# CITY OF ALBUQUERQUE

**Re: Albuquerque Memory Care Facility, 8101 Palomas Ave NE, (D19/D028),  
Request for Permanent Certificate of Occupancy - Approved  
Approved Engineer's Stamp date: 1/20/11,  
Certification dated: 12-22-11**

**Re: JEA Senior Living Memory Care Facility Grading and Drainage Plan  
Engineer's Stamp dated 12-23-10 (D19/D028)**

**Re: Albuquerque Memory Care Facility Grading and Drainage Plan  
Engineer's Stamp dated 1-20-11 (D19/D028)**

Grading and

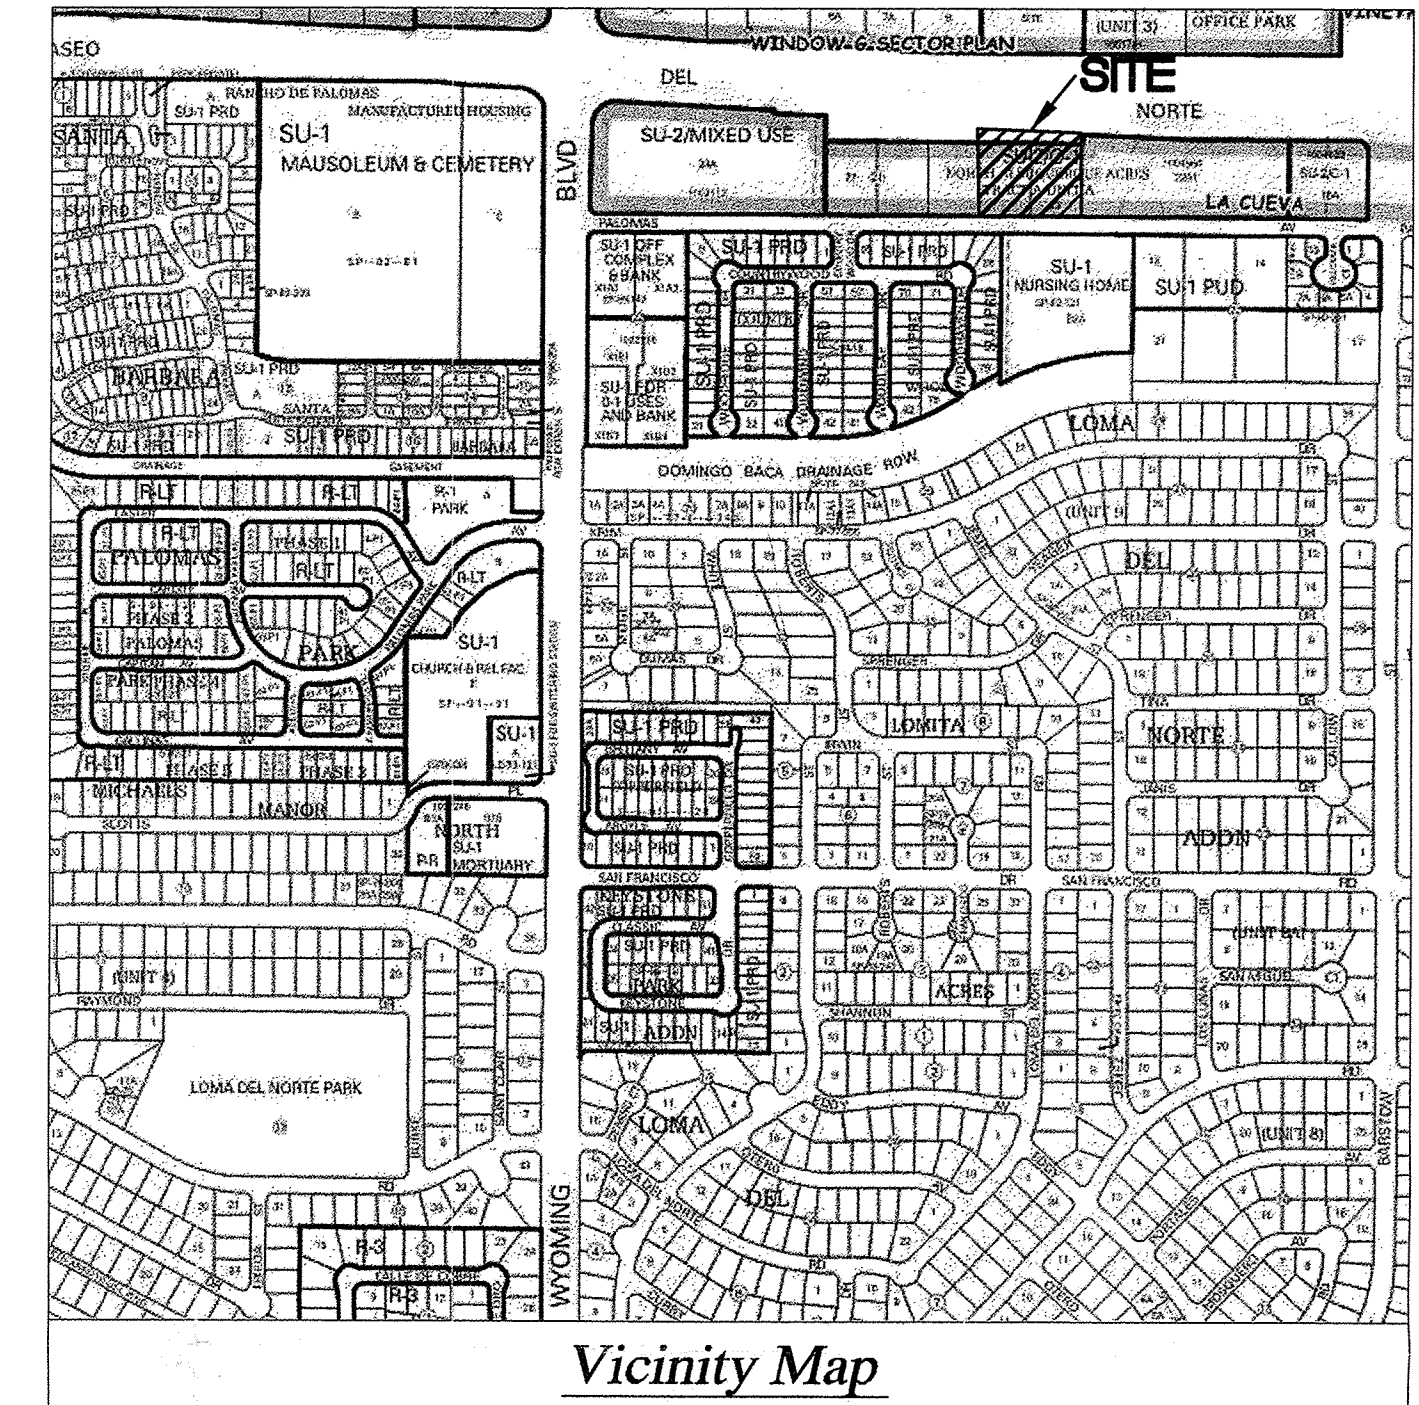
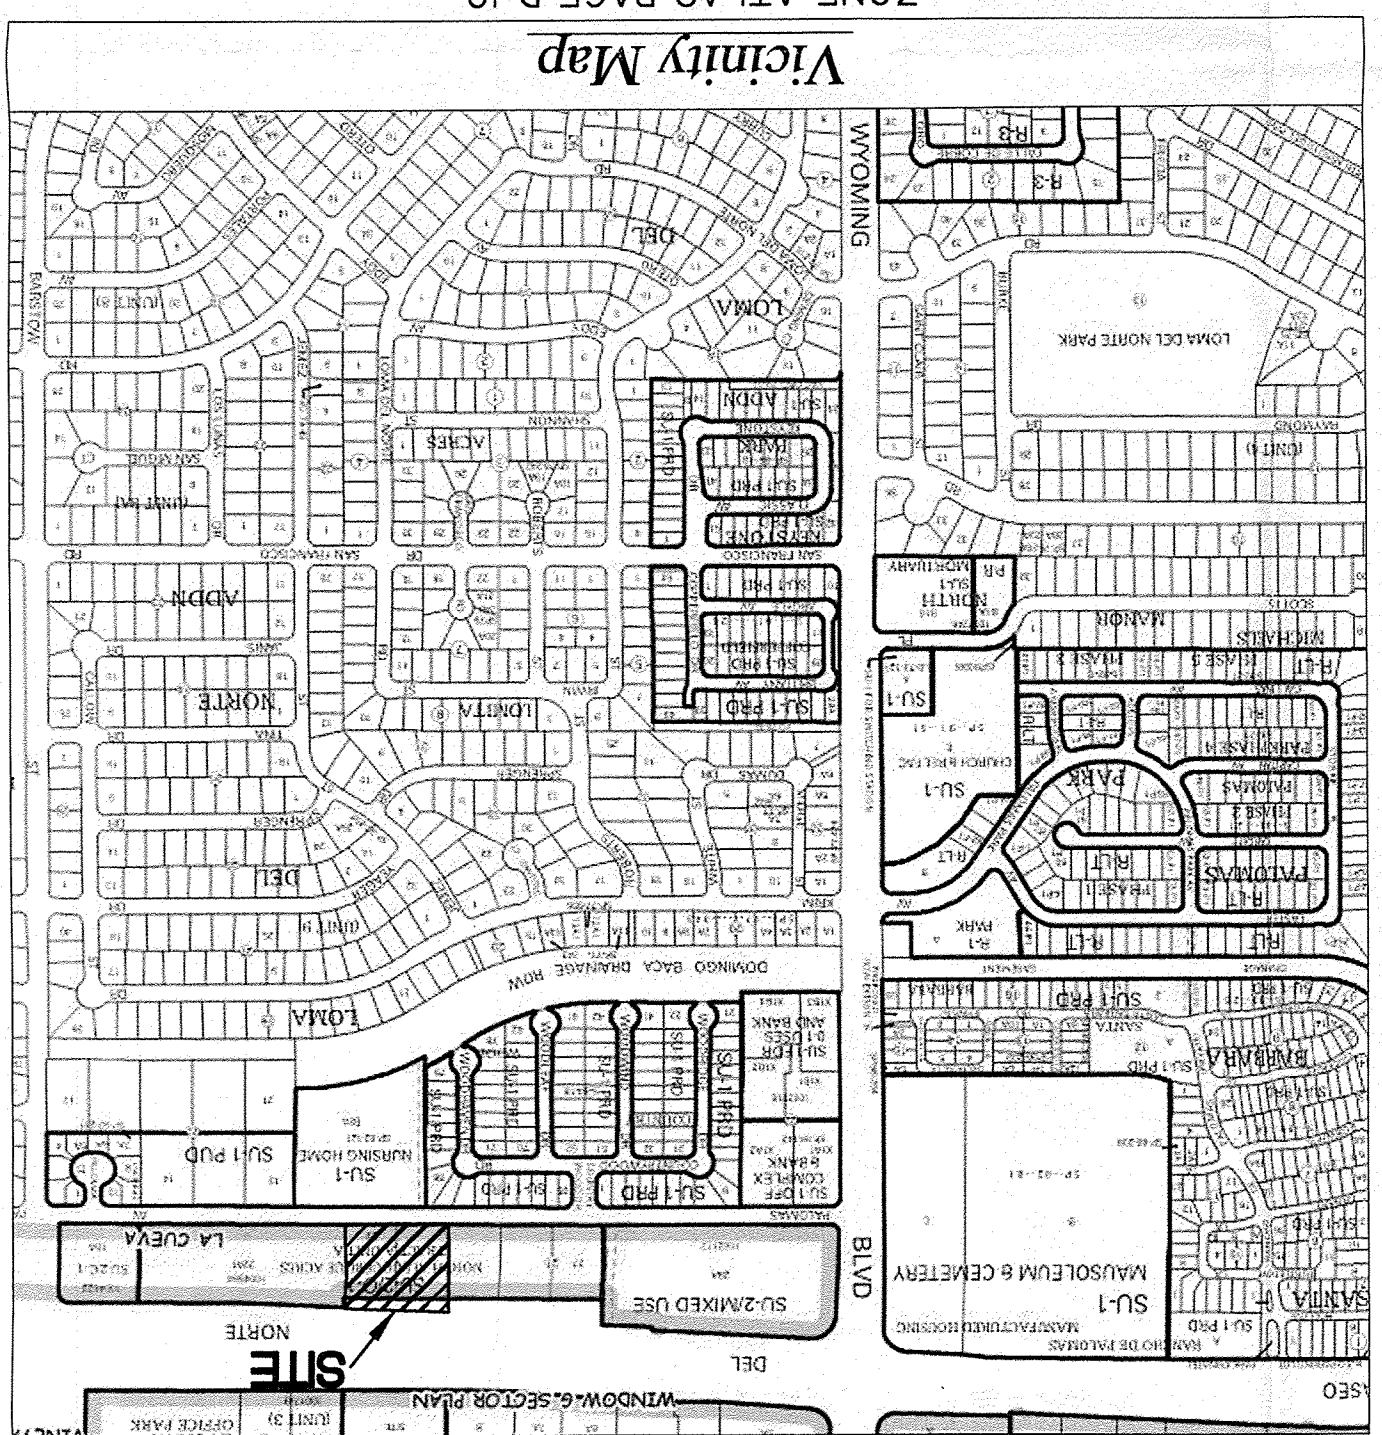
The water blocks at the drive entrances were not constructed as designed. Hydrology recommends building a "hump" north of the ADA access paths to function as a water block.

- ✓ • The water surface elevations for the Proposed Pond Volumes don't match the grades on the plan.
- ✓ • Provide quarter points and corresponding elevations in the gutter flow line in Palomas Ave. to allow verification of a water block.
- ✓ • It appears the TOW near the east end of the north wall is below the sidewalk grade. The sidewalk and associated landscape should not drain into the site.
- ✓ • Please provide grades in landscape areas that show them as depressed, as practicable.
- ✓ • The sidewalk culvert is to be built by Work Order.
